Conservation Area Advisory Committee

Meeting Date : 2 October 2017

AB/11/17/HH - Extension, 77 Maltravers Street, Arundel

PROPOSED FLOOR PLANS
DATE: July 2017
SCALE: 1:100 @ A3
JOB No: 1012
DRWG No: 105 Rev.

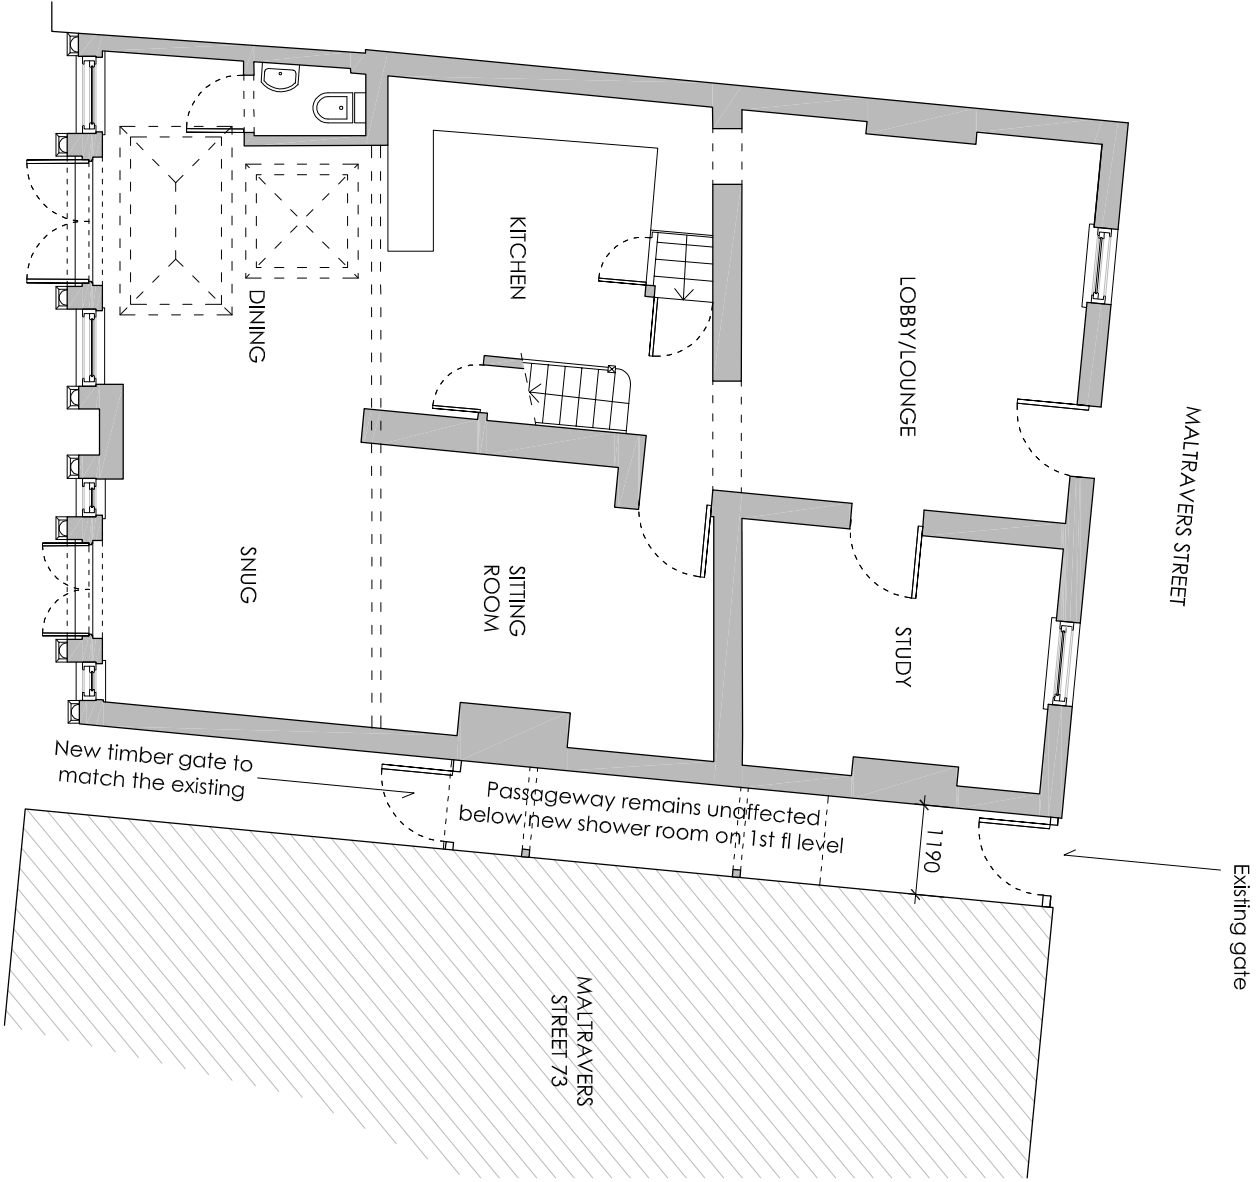
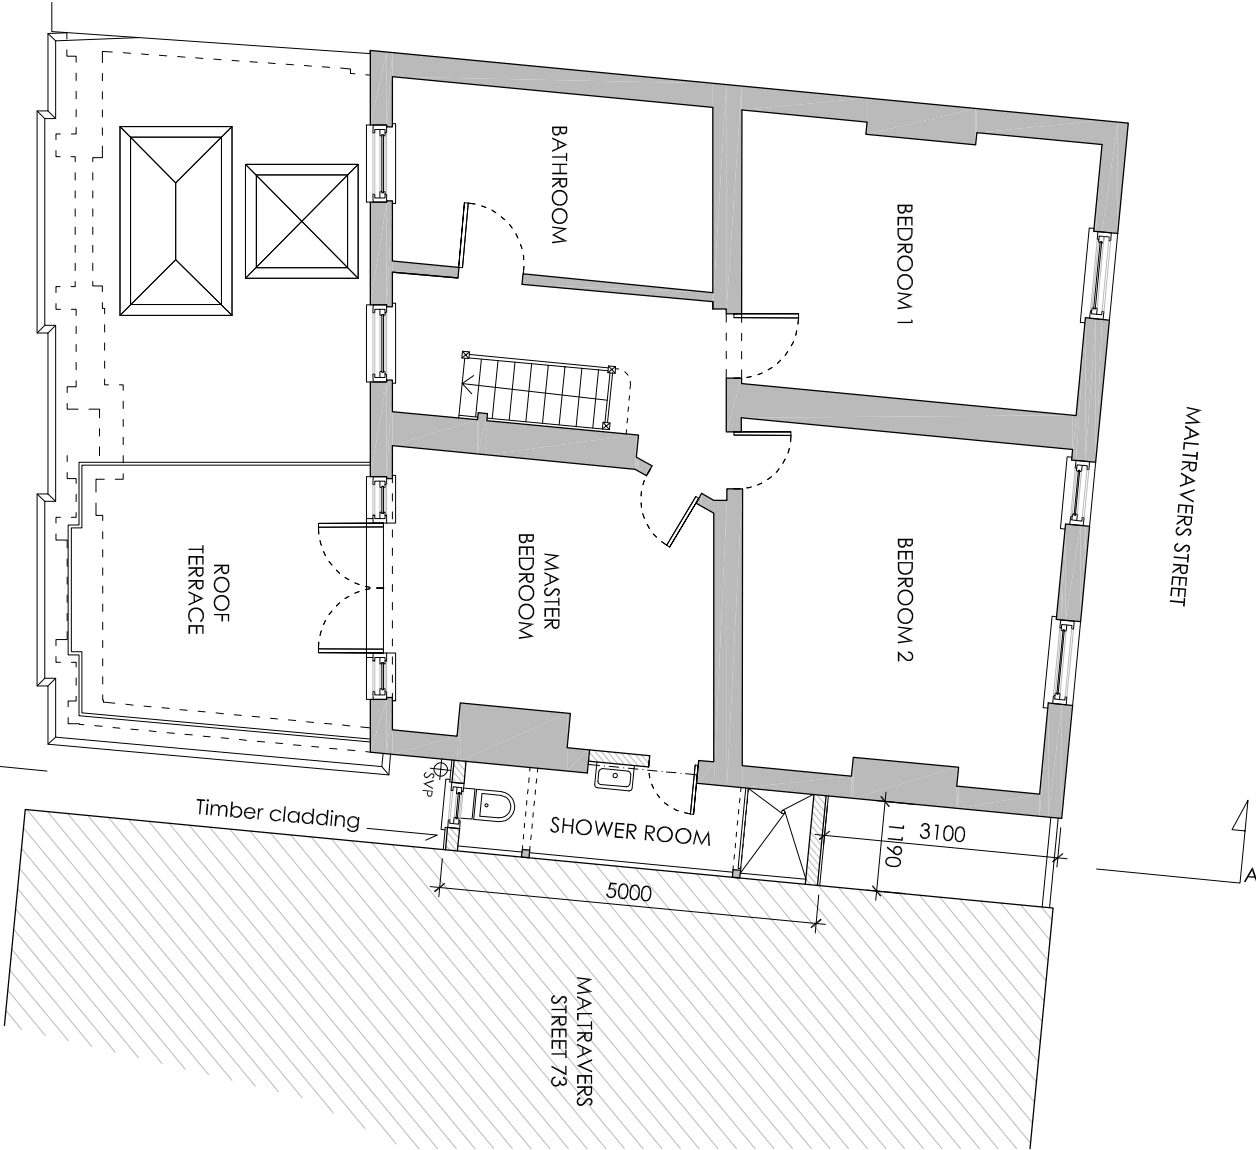
- (1) Remove the existing, inappropriate, timber doorway and framework, located at the back of pavement and relocate it in line with the new extension above. This would re-open the gap between Nos 75 and 77, thereby improving the street scene and providing visual separation between the two buildings which differ in appearance. This would also enhance their different character and improve their setting.(Perhaps Martyn could use Google Street Scane which will show better what I mean !!)
- (2) A large scale drawing of how the top edge of the flat roof will be treated at it's north and south ends needs to be submitted as part of the application. So too should materials and finishes.
- (3) It may be better to reverse the layout of the shower/bathroom to allow the window to be installed on the north (street) elevation, in order to reduce the solid mass of the extension as seen from the street.

PROPOSED NORTH & SOUTH ELEVATIONS,
STREET VIEW & SECTION AA

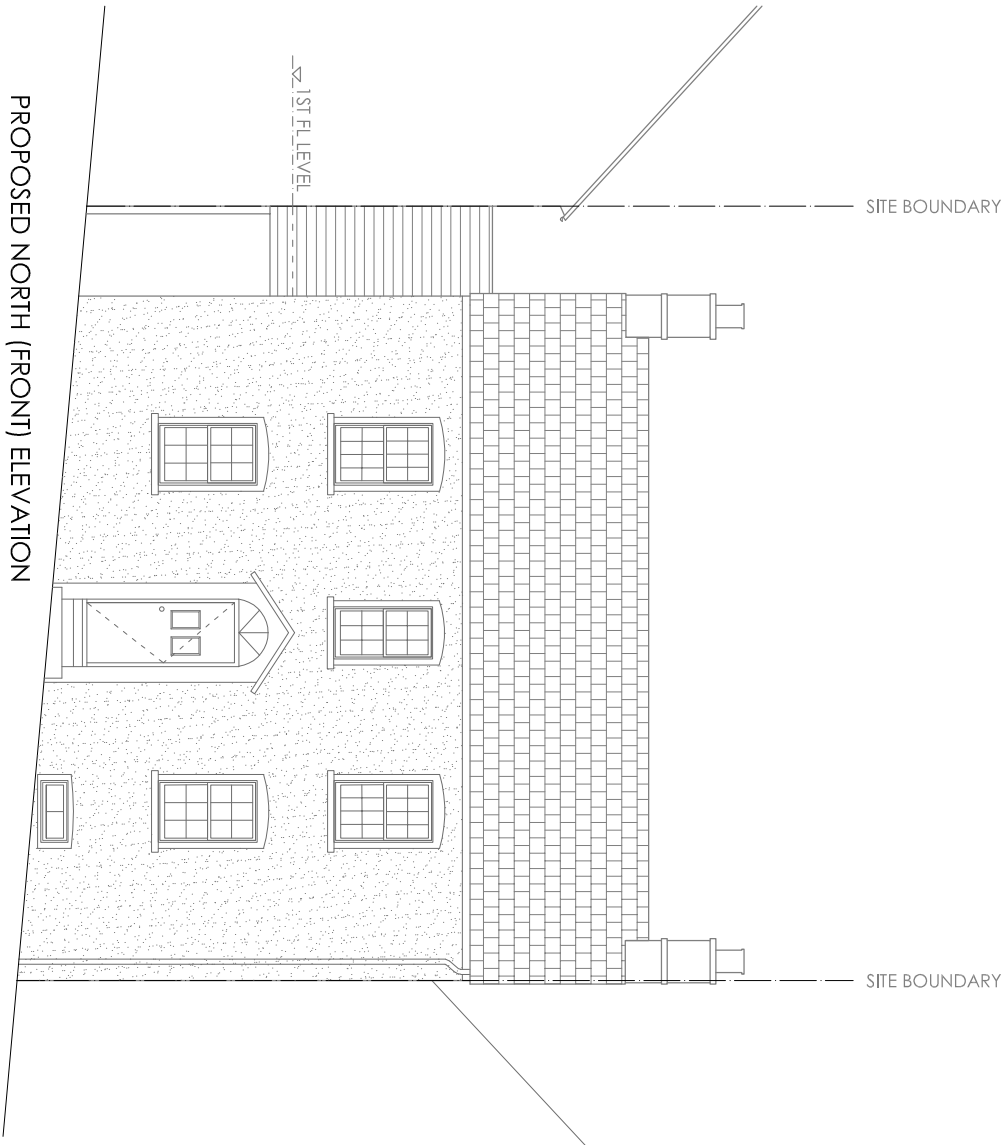
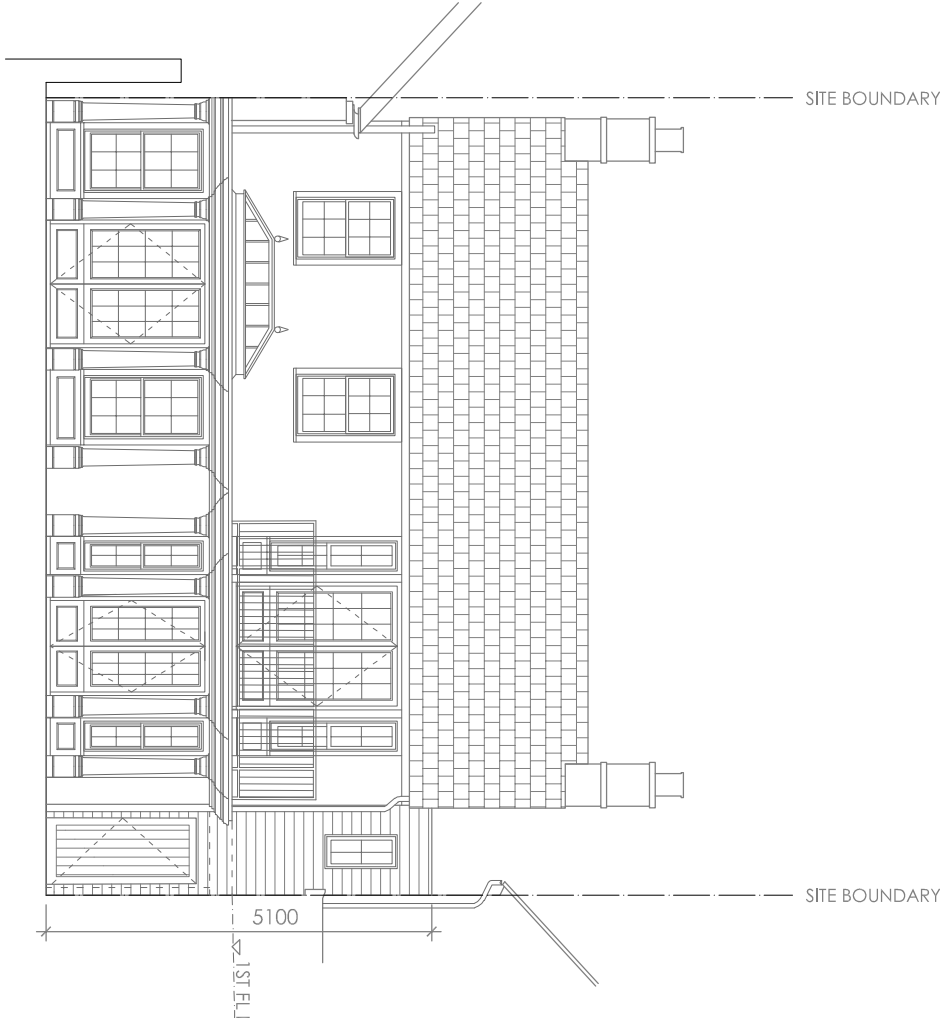
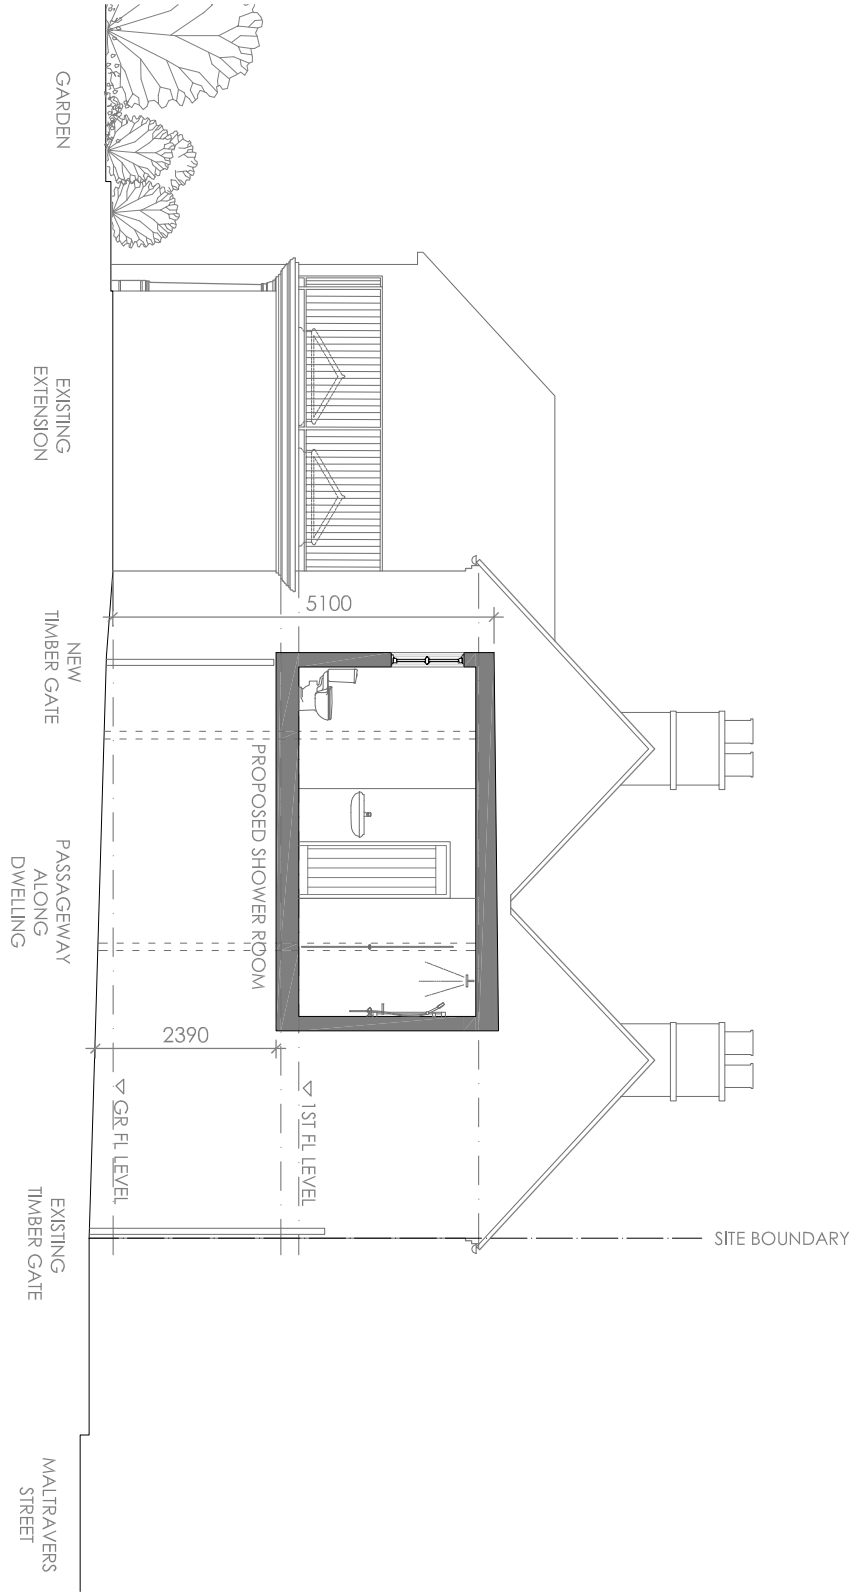
Ref	Description	Address	Design award
AB/111/17/HH	First floor side extension. This application affects the character & appearance of the Arundel Conservation Area.	77 Maltravers Street Arundel	
Comments: OBJECTION			
BN18 9BQ			
Suggested Conditions: SEE ATTACHED SHEET			
ALSO WE CONSIDER A SHALLOW PITCHED ROOF SHOULD BE CONSIDERED AS ALTERNATIVE TO THE FLAT ROOF, IN SYMPATHY TO THE QUALITY AND FORM OF THE EXISTING BUILDING.

Although relatively small, I am not certain that a flat roofed extension at first floor level is appropriate and may well be seen from the raised pavement opposite in Maltravers Road. Although the Agent gives limited examples of other similar extensions in the town, I am not convinced that they set a precedent.
